**The Sizewell C Project, Ref. EN010012**

## **Comments on any additional information/submissions received at D2**

**Suffolk County Council Registration ID Number: 20026012**

**24 June 2021**

Plate 2.1: Phasing Schedule

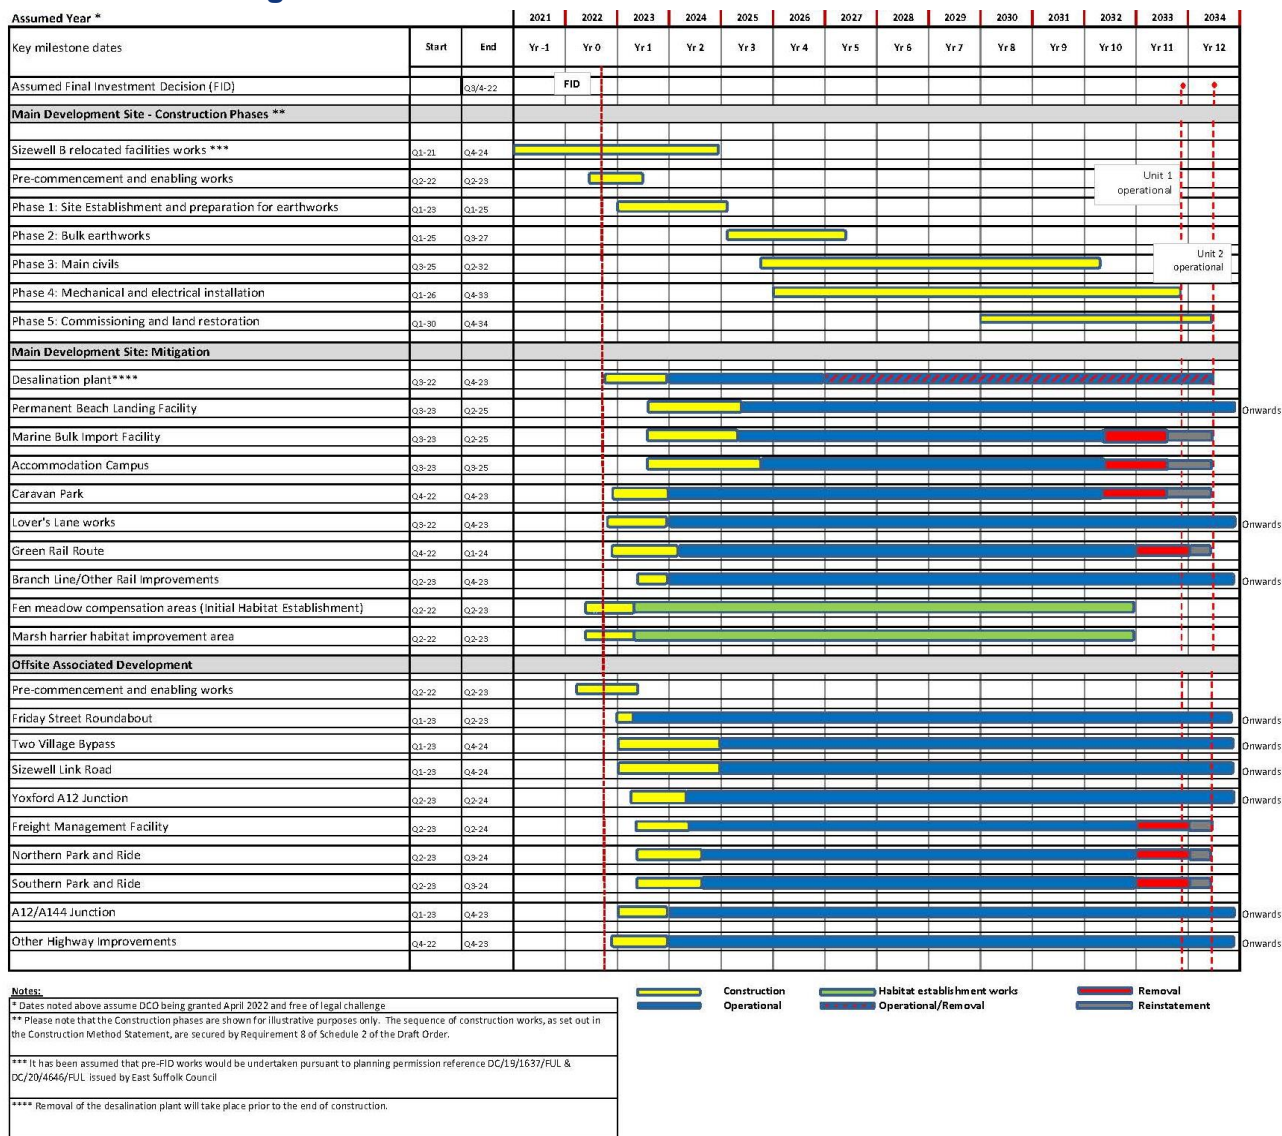
7. However, SCC is concerned that the A12/B1122 junction at Yoxford is now delayed until 6 months after Final Investment Decision (Plate 1.1). This location is a critical pinch point in the highway access to Sizewell C and a significant amount of work is required within the existing highway limits to tie in the new roundabout with no suitable diversion route for the B1122 traffic.

8. To gain a better understanding of the interrelationship of the phasing, and resulting demand for Associated Development facilities, SCC considers that it would be very helpful to include profiles of HGV movements and numbers of workers within Plate 1.1. This would assist in setting suitable controls and assist future monitoring to ensure key assumptions in the modelling remain valid.

9. The removal phase for the permanent beach landing facility (Plate 1.1 [REP2-044]) is presumed to refer to taking down of the deck structure but this should be clarified.
